**Re: Yearwood Bldg Grading and Drainage Plan  
Engineer's Stamp dated 8-13-10(K20-D58)**

**RE: Grading and Drainage Plan  
Yearwood(K20-D058)**

**Re: Yearwood, 341 Eubank NE**  
**Grading and Drainage Plan**  
**Engineer's Stamp dated 05-26-10 (K20-D058)**

ENGINEER'S SEAL  DAVID SOULE P.E. #14522	YEARWOOD 341 EUBANK GRADING AND DRAINAGE PLAN  Rio Grande Engineering 1606 CENTRAL AVENUE SUITE 201 ALBUQUERQUE, NM 87106 (505) 872-0989	DRAWN BY WCWJ
		DATE 5-24-10
		2115-LAYOUT-5-18-10
		SHEET # =
		JOB # 2115

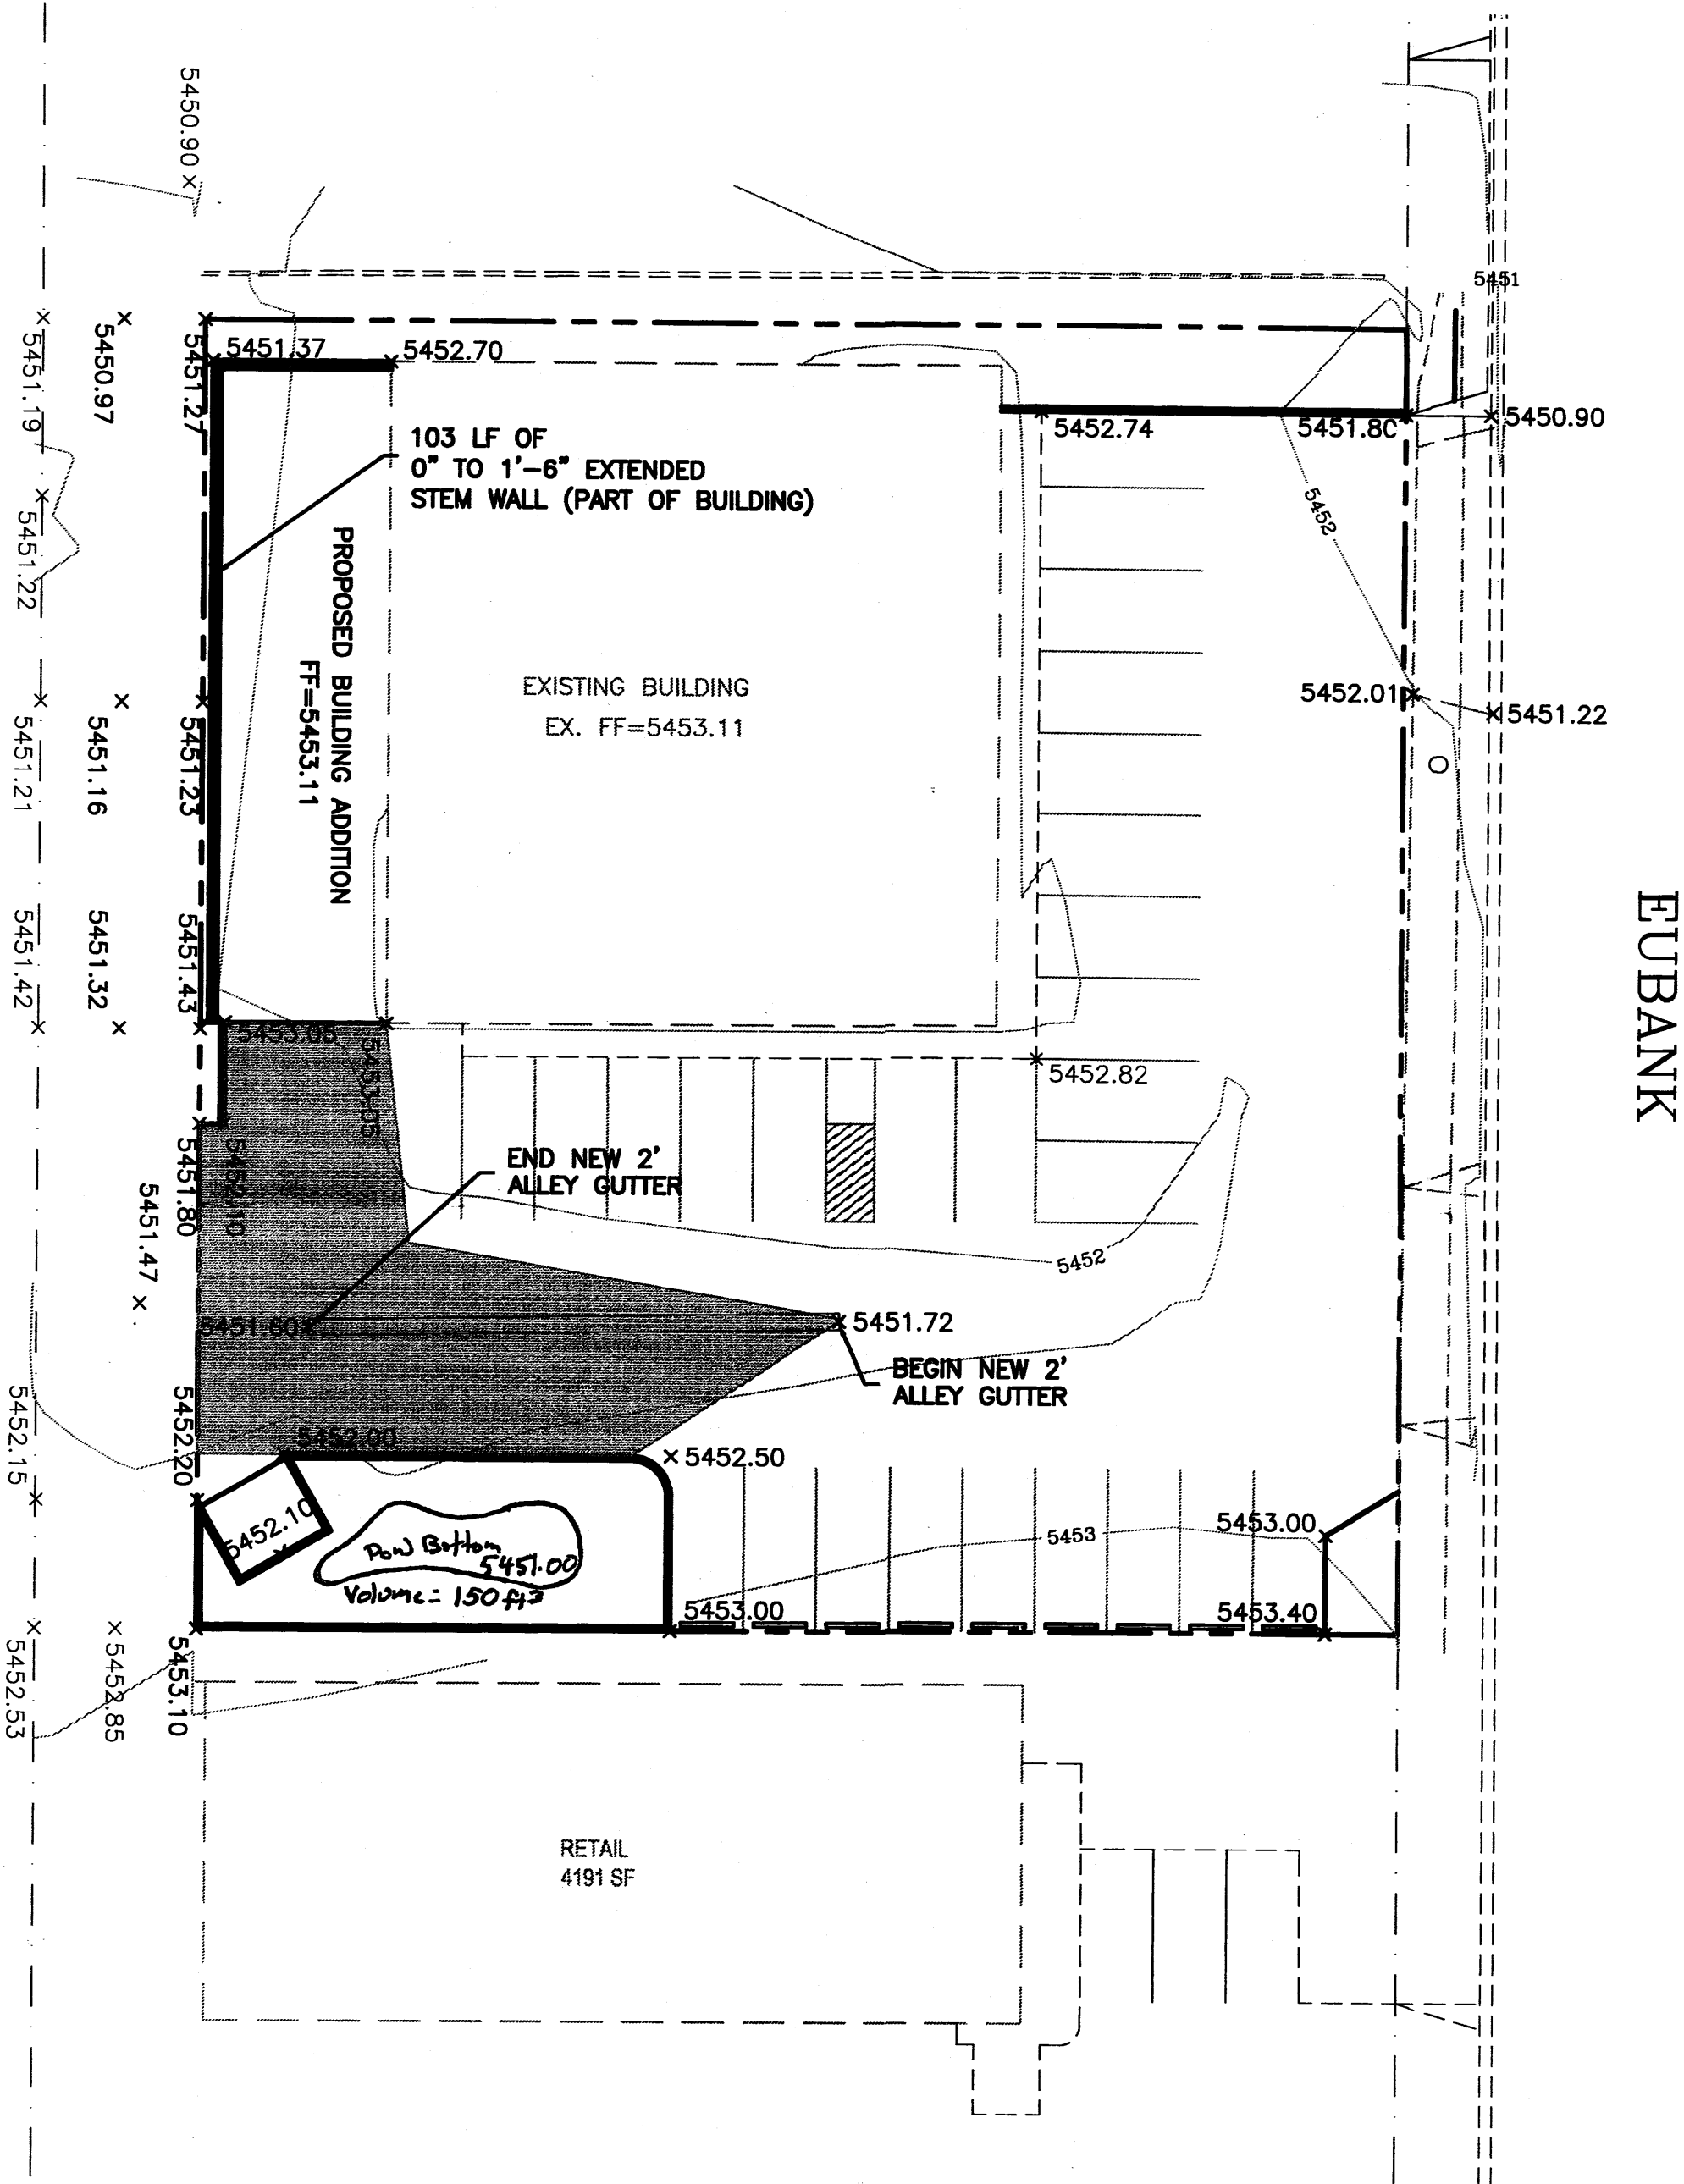
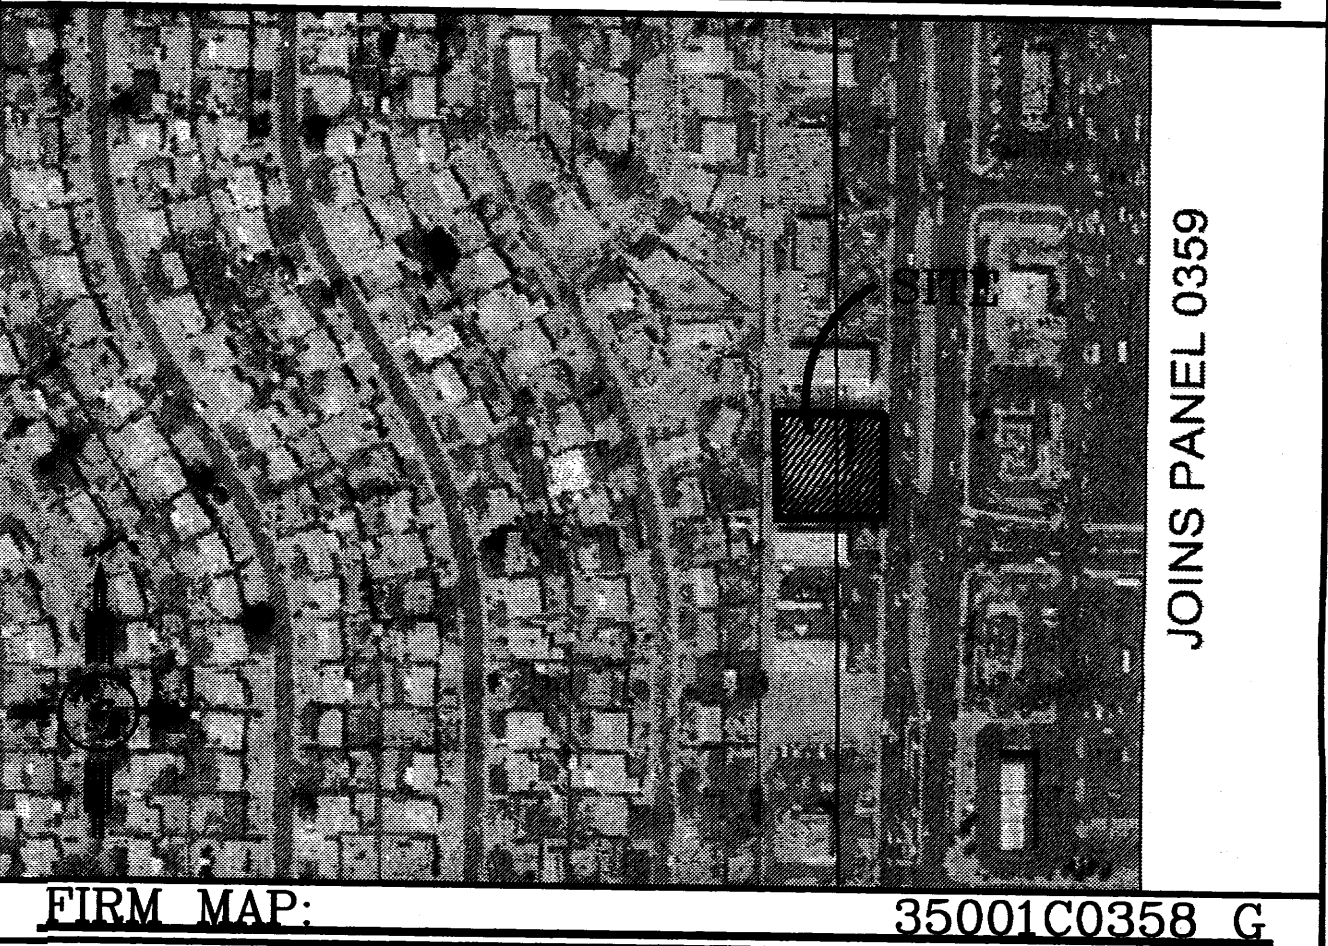
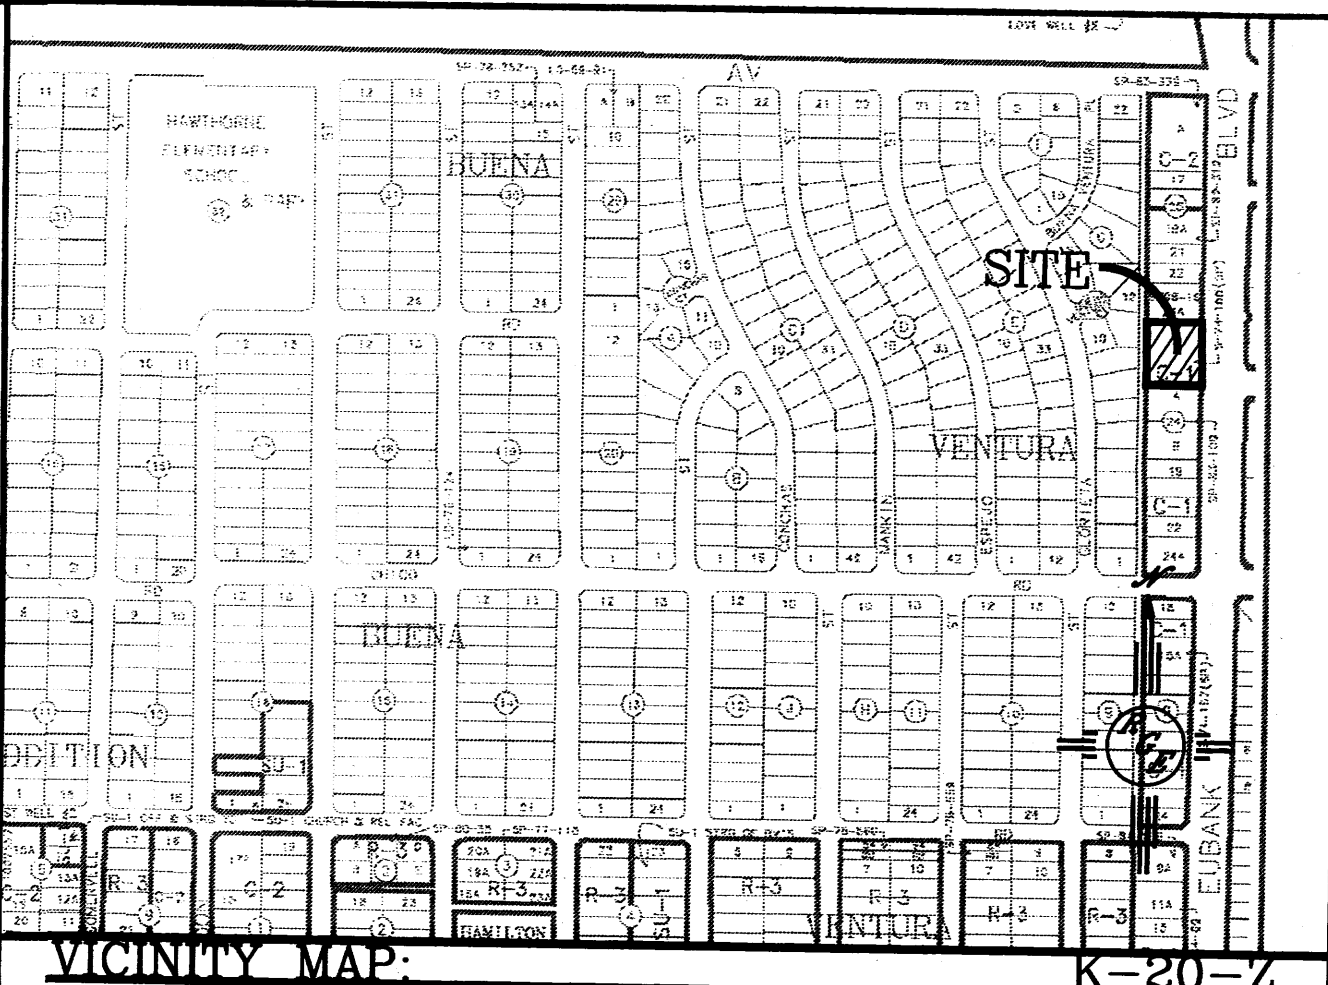
1. The new roof needs to drain into the parking lot, then to the alley.
2. Is there a new landscape area in the NE corner.
